## **SECTION 4.55(1A) MODIFICATION APPLICATION TO SSD7228 SYDNEY ZOO – MODIFICATION 2**

This application has been prepared by Ethos Urban on behalf of Sydney Zoo, pursuant to section 4.55(1A) of the *Environmental Planning and Assessment Act 1979* (EP&A Act) to modify State Significant Development Consent 7228 relating to Bungarribee Park (Western Sydney Parklands) the Sydney Zoo in Bungarribee Park, Western Sydney Parklands (the site).

The modification relates to the reconfiguration of the aquatic habitat exhibit and its associated boardwalk access path.

Sections
Aquatic Habitat Exhibit
B6

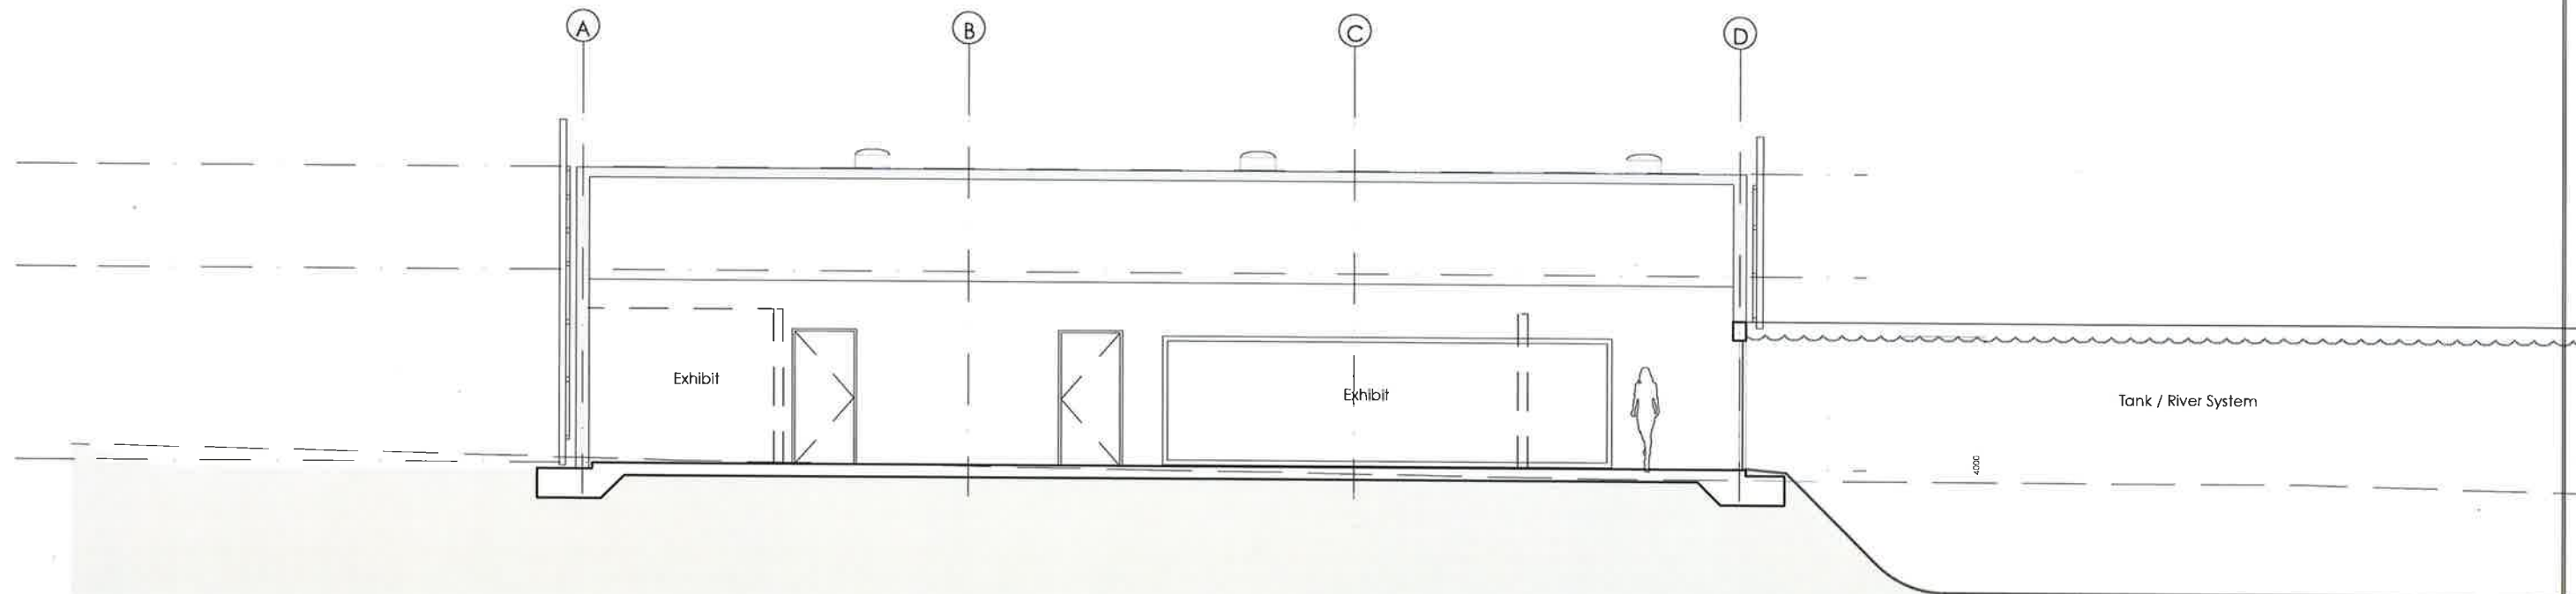
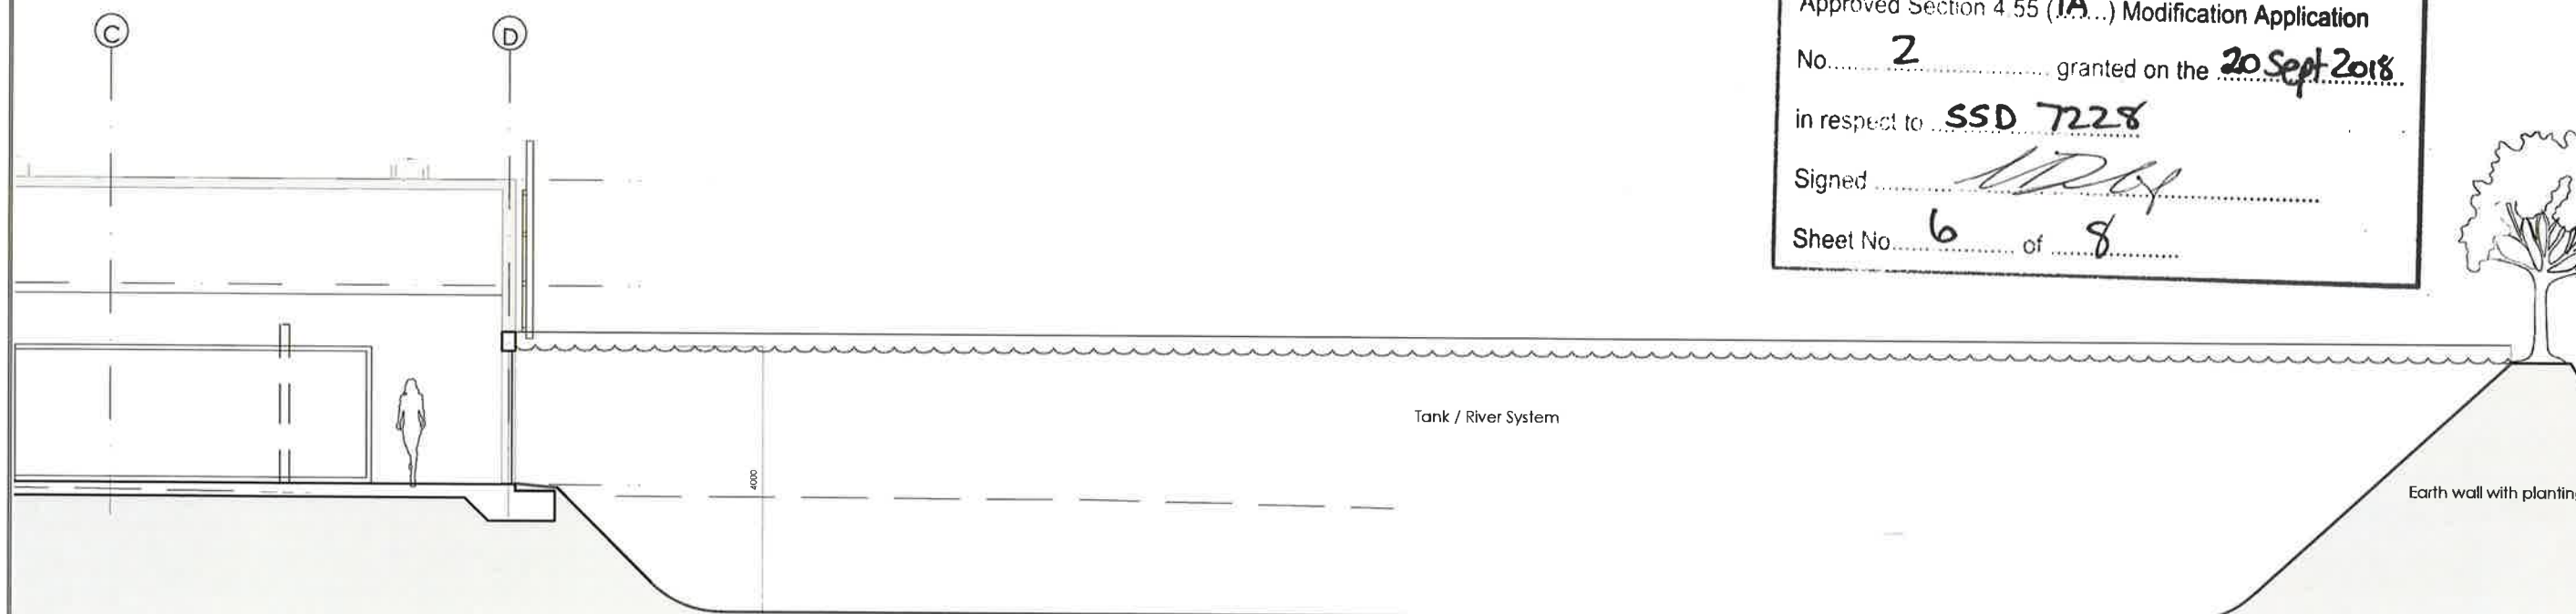
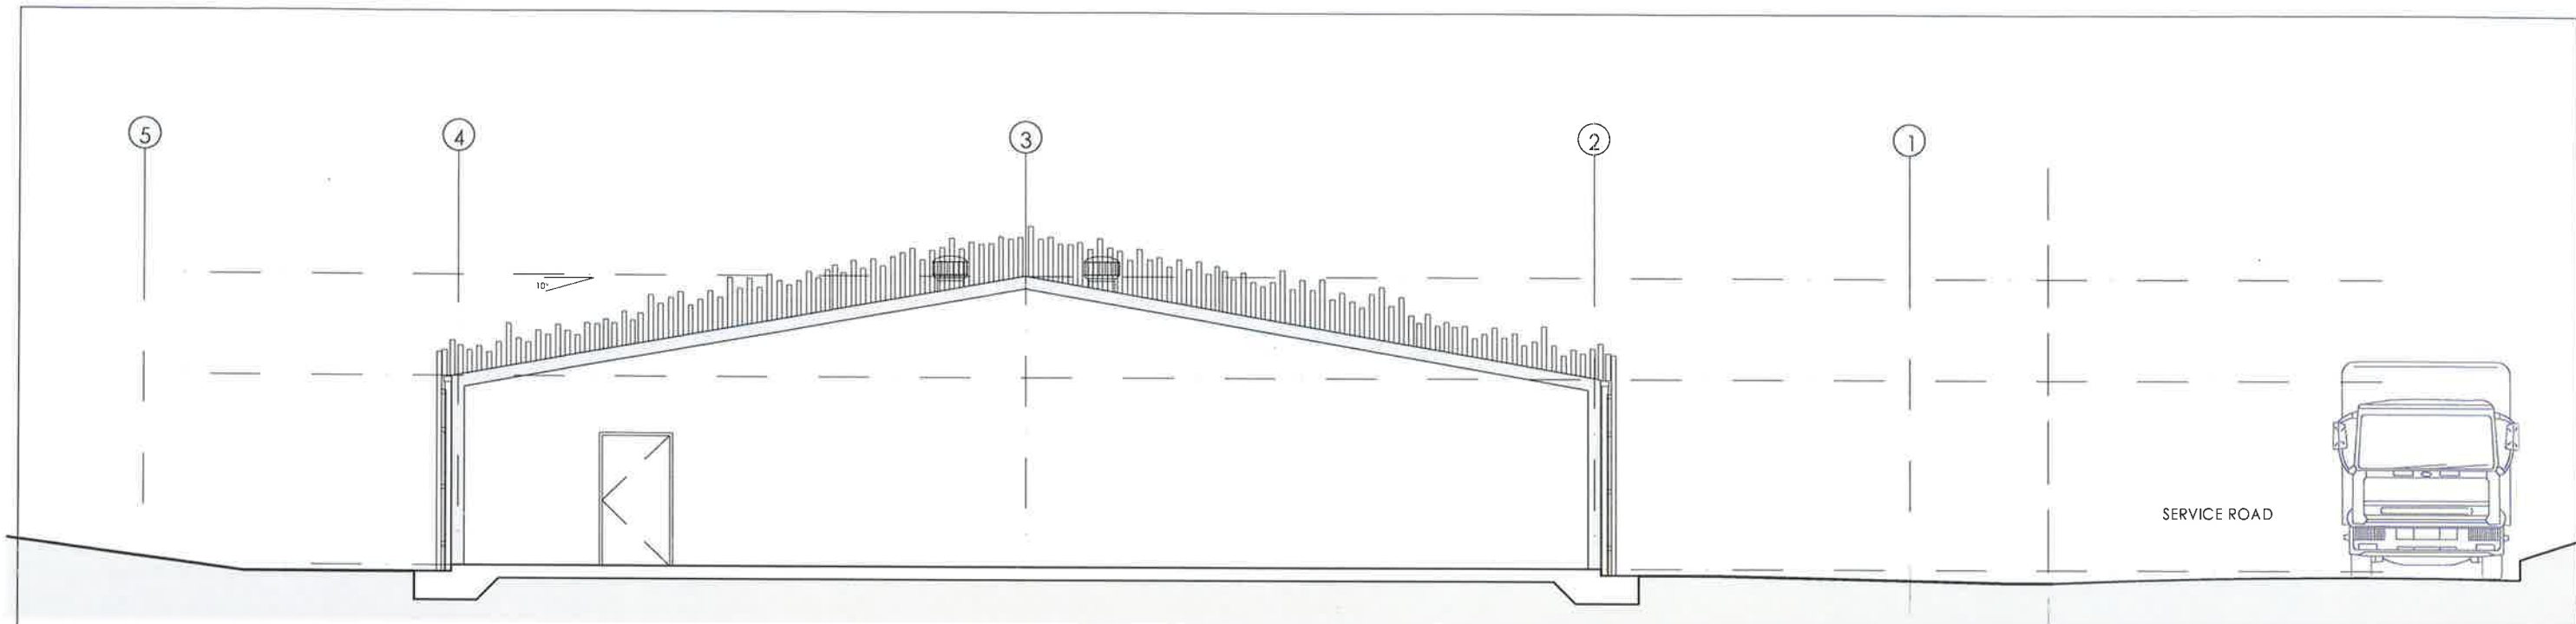
The new tank proposed to the east of the building will be used to exhibit a variety of aquatic specimen through an underwater viewing window. It will be surrounded by embankments and vegetation, to ensure it blends into the landscape, with a water depth of approximately 4m. Fencing will be used to remove and reduce the risk of intrusion by guests in accordance with Department of Primary Industries (Exhibited Animals) requirements. Access to the tank will only be available to curators and zoo staff.
